From: Martyn White
Sent: 08 March 2019 15:18
To: Planning.Responses
Cc: Zac Denton
Subject: AB/137/18/HH

AB/137/18/HH

The application relates to a very attractive red brick property near the top of King Street. It fronts straight on to the pavement and due to its size plays an important role on the street-scene.

New double glazed window detail

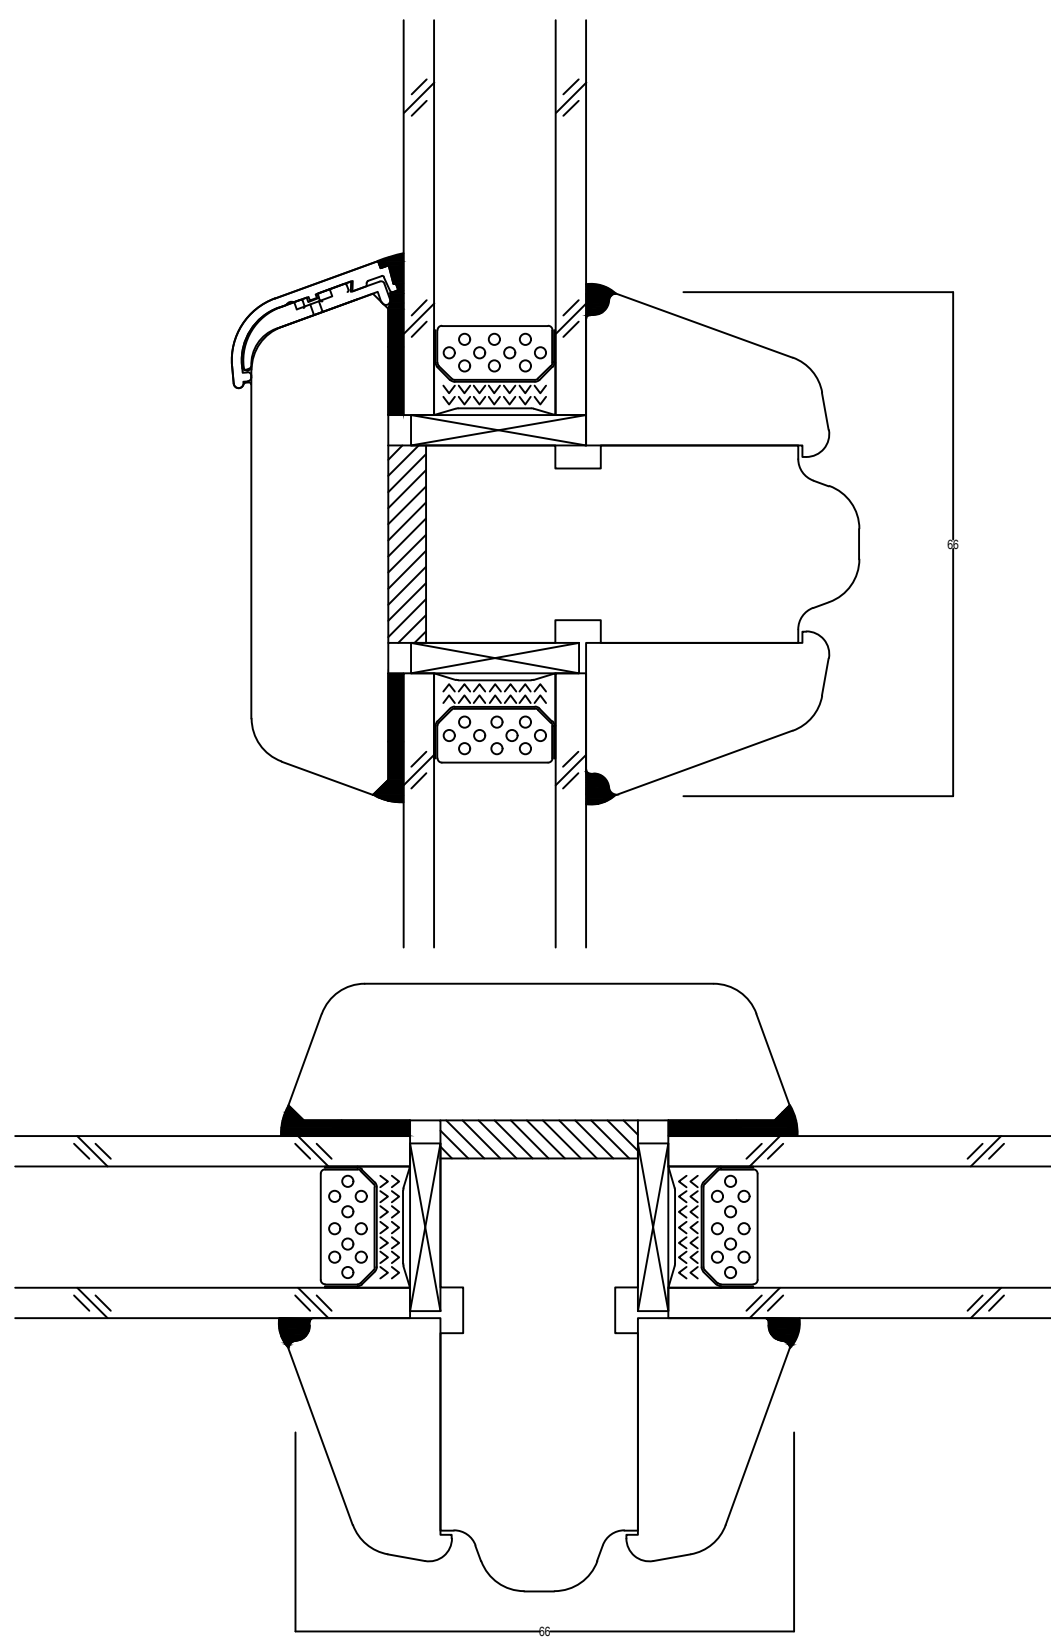
Windows are an important feature within a historic building, and their replacement should be carefully considered. Good practice is that existing windows should be retained and repaired prior to their wholesale replacement. Such an approach could potentially allow new glazing units to be introduced within the existing frames (subject to further consideration).

The existing windows play an important function in establishing the character of not only this property, but also the neighbouring buildings. Any alteration should be carefully designed so as to minimise any change in appearance, and therefore harm. A key element of this will relate to the dimensions of the glazing bars and the frames.

It is positive to see that the Design and Access Statement notes that the applicant plans to ensure that the woodwork thickness and detailing of the windows will be like for like apart from the double glazing aspect. It is hoped that this will exactly follow the details of the existing window design. You may wish to ensure that this is the case.

Ideally, the replacement glazing would be in the form of the slimmer units so as to further minimise their impact on the dimensions of the frame.
